**Consultation Response from Mike Hibbert,
KC Waste Strategy(Refuse & Recycling)**

2023/93782 14, Firth Street, Huddersfield, HD1 3BA

Erection of extensions and alterations to form 16 student apartments

Responding Ref: WPS 23-081

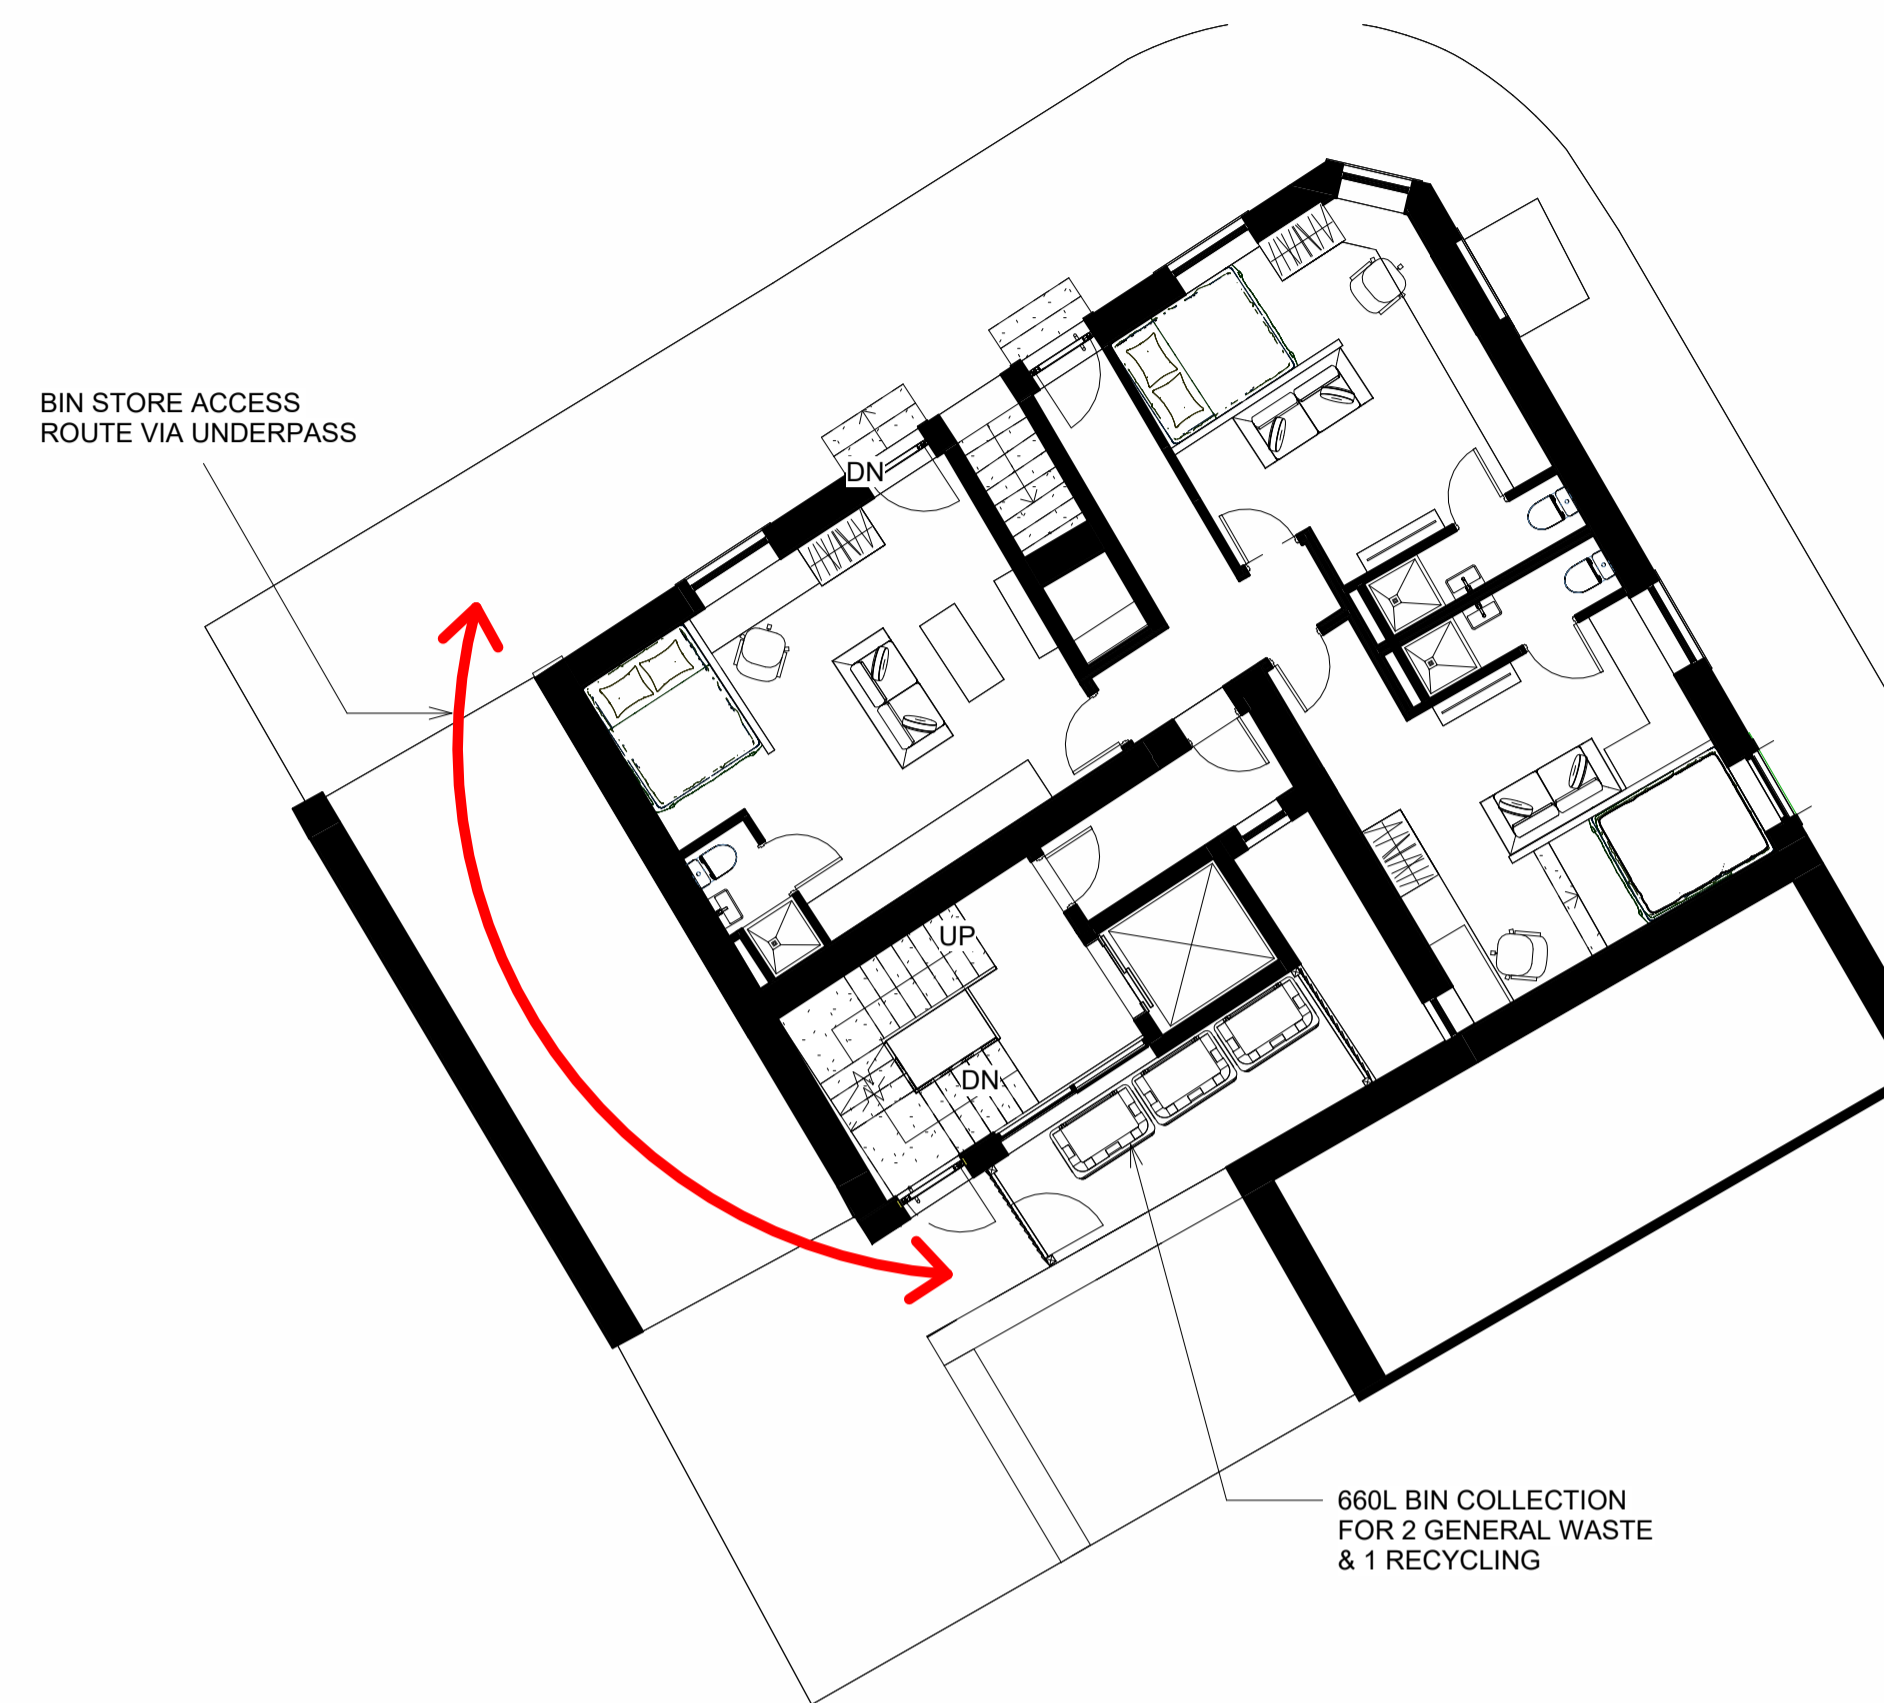
The application includes PROPOSED SITE PLAN & REFUSE PROVISION Drawing number (100) 08 Dated September 2023 that shows the location of the bin store and access route to Firth Street.

The application form states that Bin Storage is provided, and the plans show Provision for 2 X 660ltrs residual and 1x 660ltrs recycle.

- Waste arisings from 16 apartments will be between 1900ltrs and 2880ltrs. The proposal is for provision of 3x 660ltrs wheeliebins (2 residual and 1x recycle). Student apartments have the potential to generate large quantities of waste. To reflect this would be preferable to have storage for 2880ltrs. This would be possible with the use of three 1100ltrs wheeliebins.

- Guidance indicates the floor space for 660ltrs wheeliebins is 1560mm x 970mm with space required to manoeuvre the bins within the store. The proposed store on the plan shows bins of approximately 1300mm x 860mm. There does appear to be sufficient space within the store to accommodate 1100ltrs bins rather than 660ltrs and the gate width of 1.54m will allow passage of wheeliebins. The bin store does not appear to be located under apartment windows.

- The communal waste storage area should be secure to prevent unauthorised use, damage or theft. The gates to the communal store or those under the access arch to the rear yad should be secured.

- Storage should address the fire risk issues presented by large quantities of waste. The store should be constructed of suitable materials to contain and prevent the spread of fire. See BS5906:2005, Building Regs 2010 Part H6 and CFWA-E Guideline No 7:2022 F.

- Access from the bin store to the Bin Collection Point (BCP) at the front of the property next to the highway via the archway should be constructed to withstand point loading and movement, impacts of larger bins over time, and to resist future rutting, pitting, cracking or other such surface degradation that would impair bin manoeuvring. The location of the bin store may mean access is impeded by parked cars between the store and highway.
- RCV Cleansing staff will not pull out the bins from the bin store.
